From: Simon Davis
Sent: 01 March 2018 11:49
To: [REDACTED]
Subject: RE: Y/52/17/DOC - Longacre, Maypole Lane

Subject: RE: Y/52/17/DOC - Longacre, Maypole Lane

Comments on proposals;

Lavender Cottage Drainage Plan

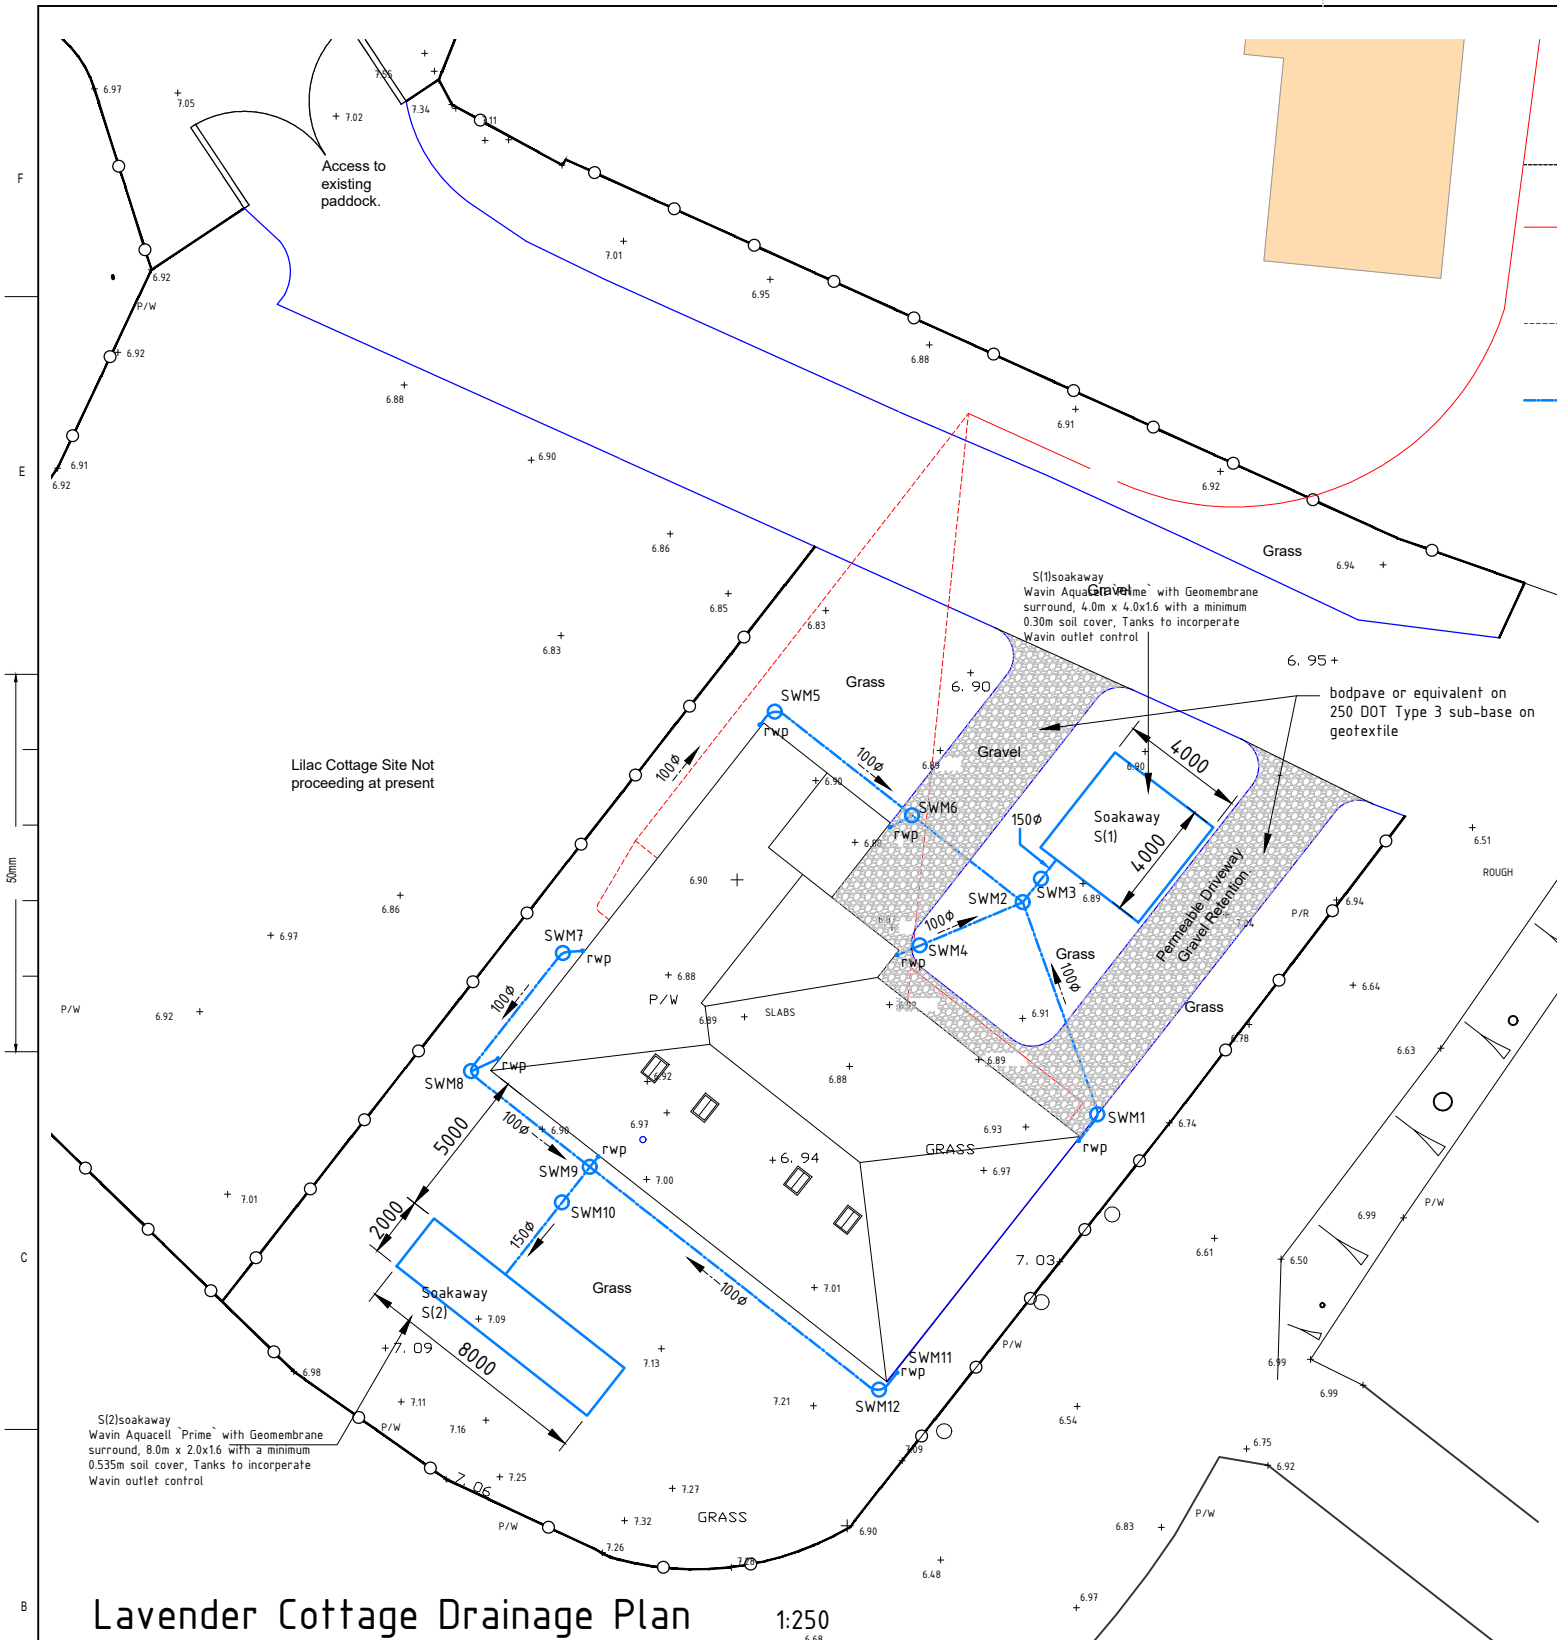
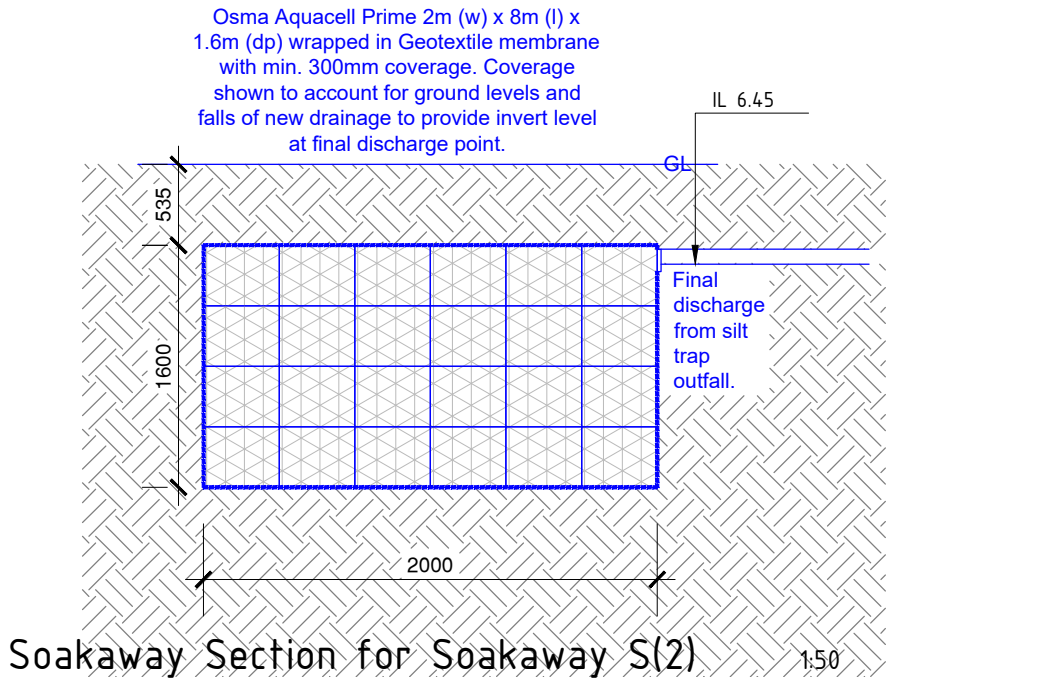
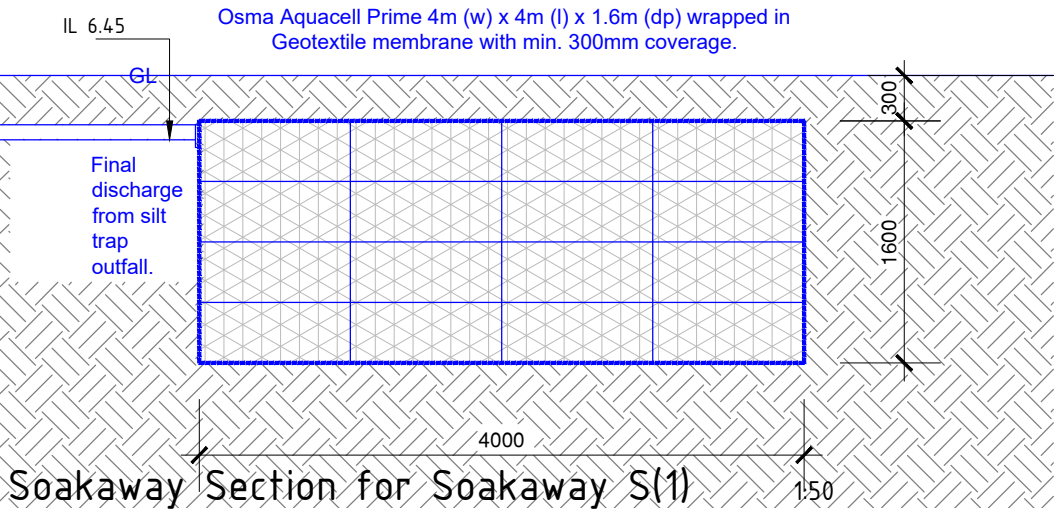
1. Alter soakaway detail to make it clear that a 'permeable' geotextile membrane is to be used.
2. Include a construction detail for the permeable paving, with the type 3 stone fully wrapped in permeable geotextile.
